KITITAS COUNTY

MEMORANDUM

TO: All Staff
FROM: Public Works Plan Review Team
DATE: March 25, 2026- 4/6/2026 UPDATE
SUBJECT: BL-26-00003 Hanson

- Proposed
- Site Plan

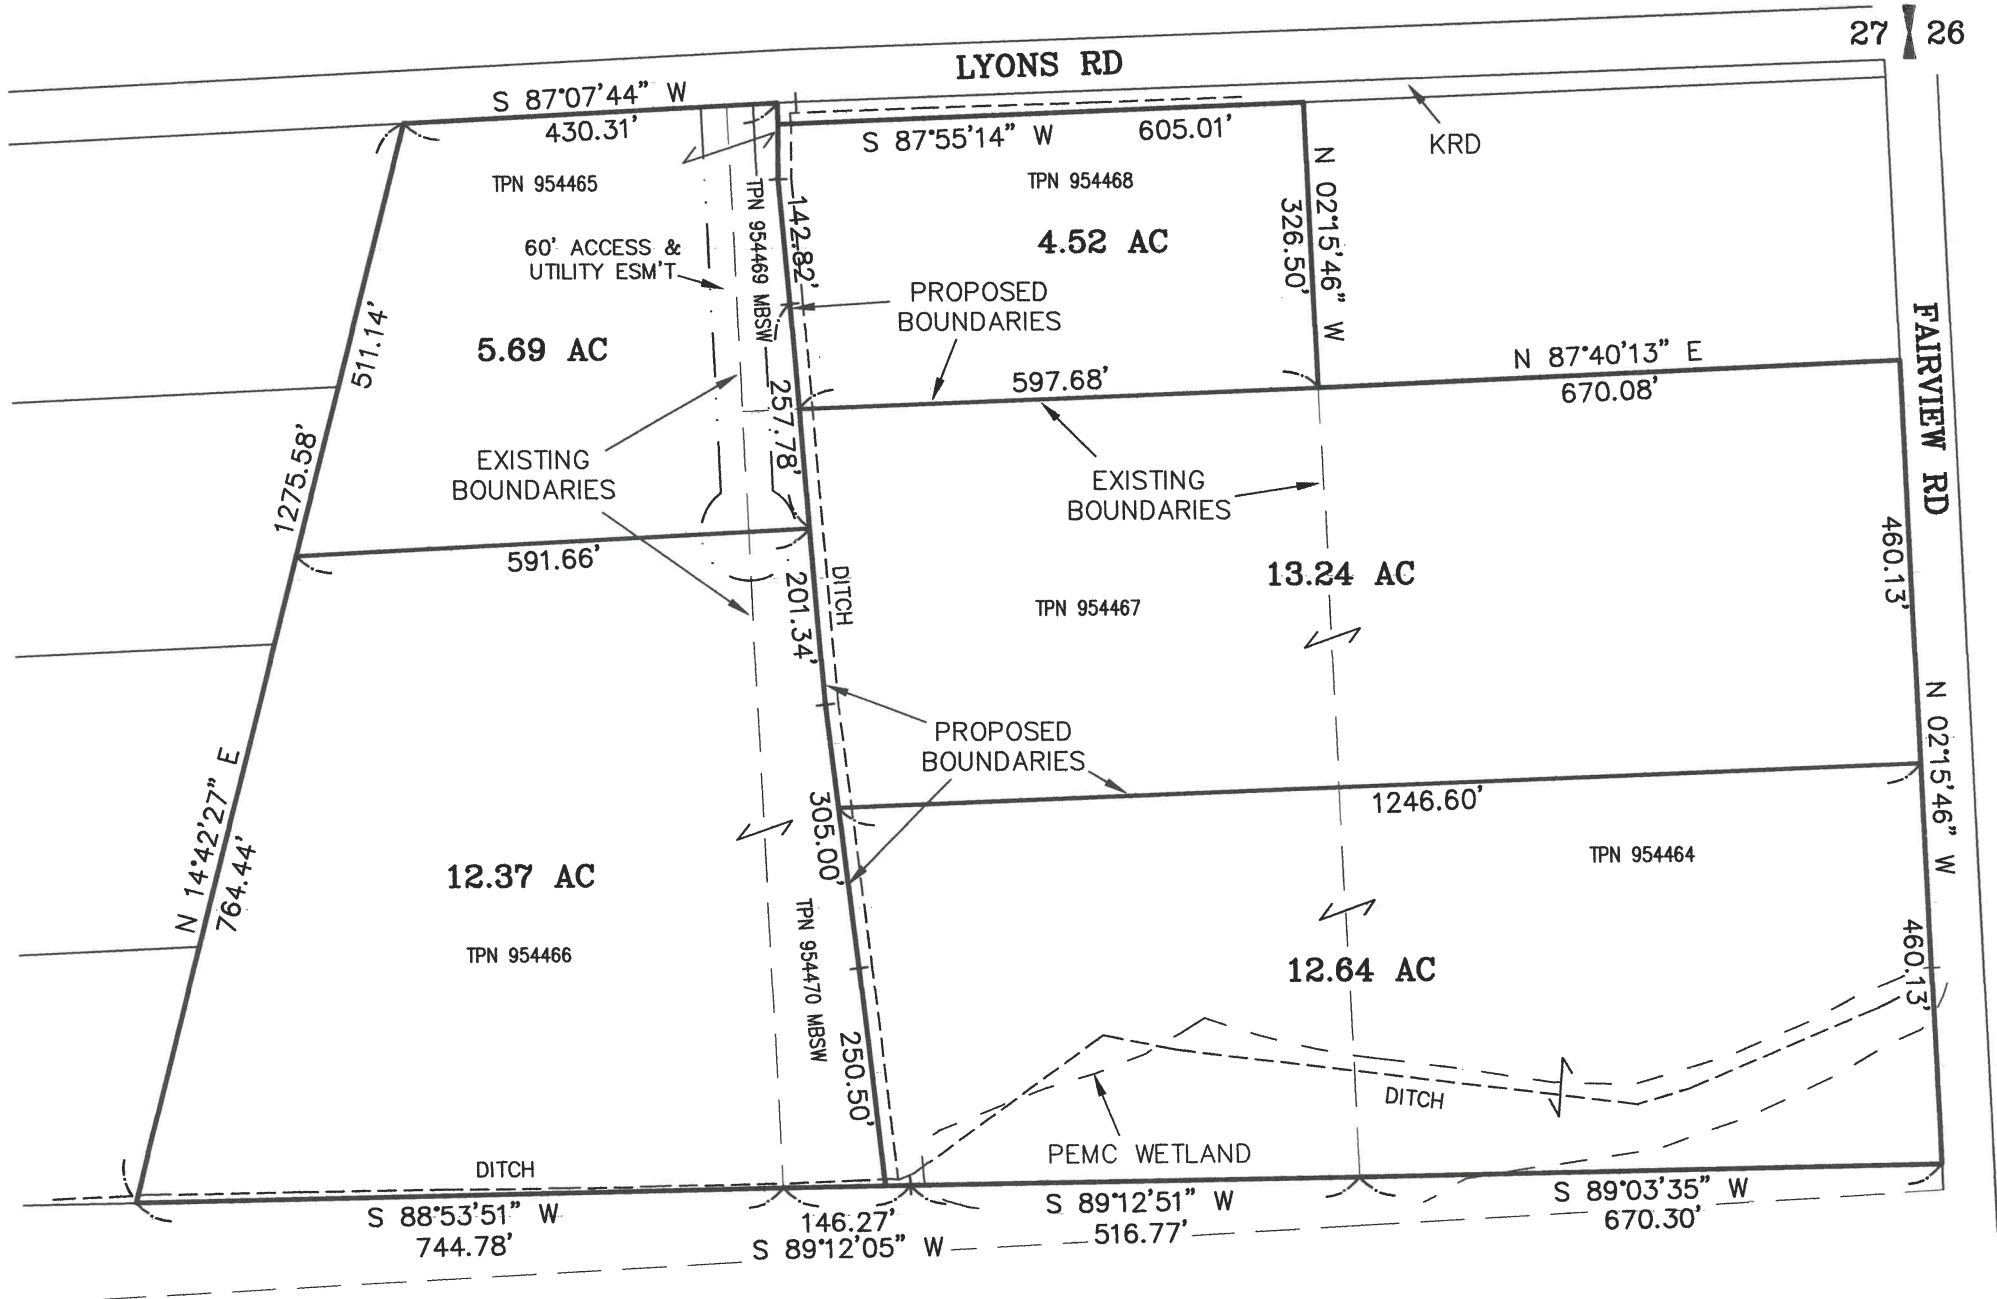
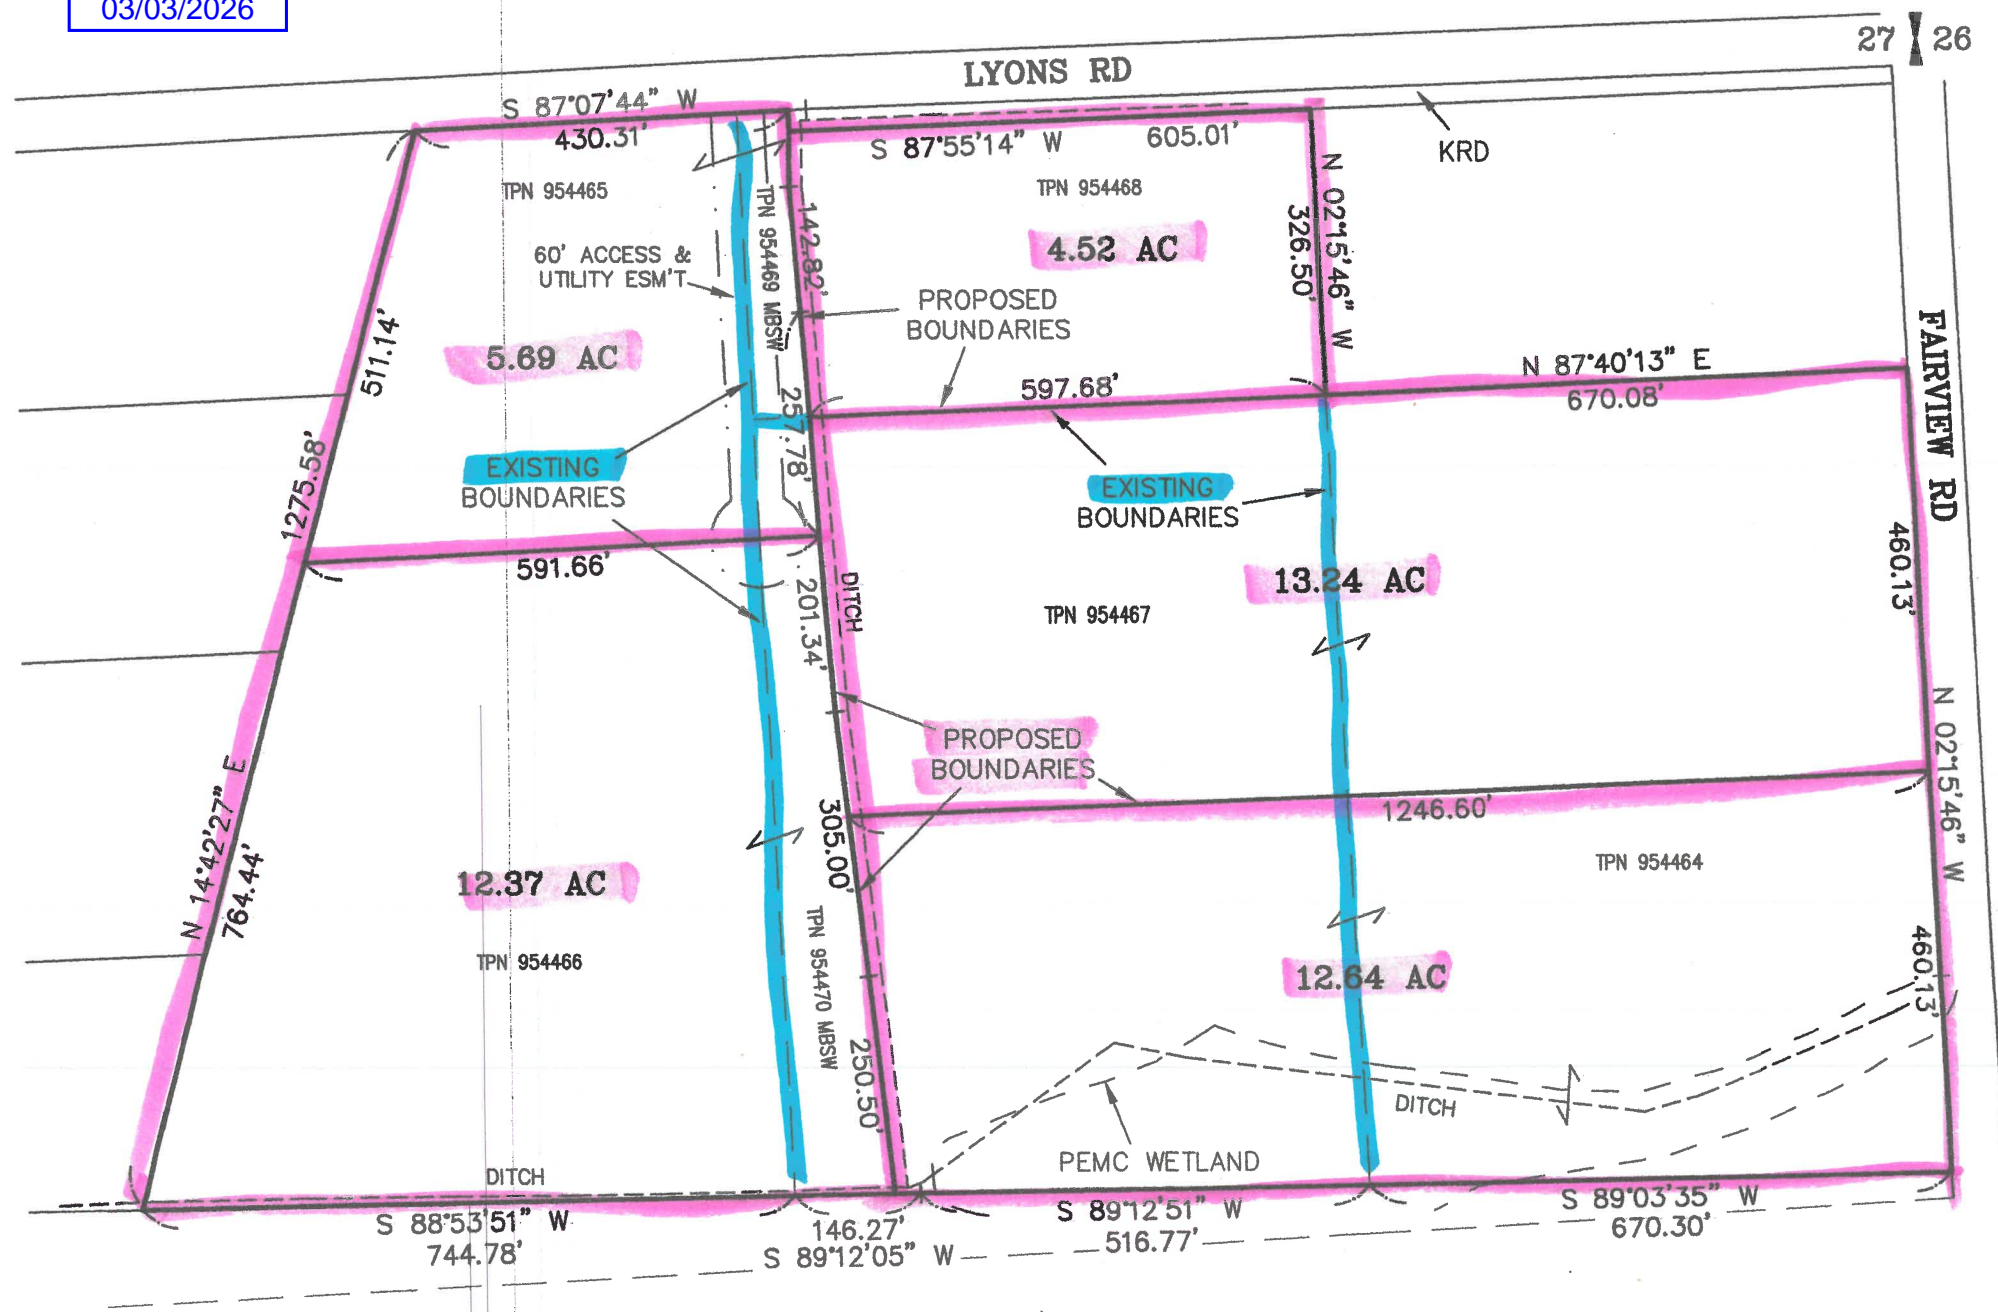
ACCESS	<ol style="list-style-type: none"> 1. Provide easements for access to lots from joint-use driveways. Lyons Road and Fairview Road have an access spacing of 300 feet between driveways on the same side of the road. 4/6/2026 UPDATE- comment has been addressed. 2. An approved access permit shall be required from the Kittitas County Department of Public Works prior to creating any new driveway access or altering existing access. 3. Maintenance of driveway approaches shall be the responsibility of the owner whose property they serve. The County will not maintain accesses. 4. Any further subdivision or lots to be served by proposed access may result in further access requirements. See Kittitas County Road Standards. <p>In addition to the above-mentioned conditions, all applicable Kittitas County Road Standards apply to this proposal. Access is not guaranteed to any existing or created parcel on this application. (RC)</p>
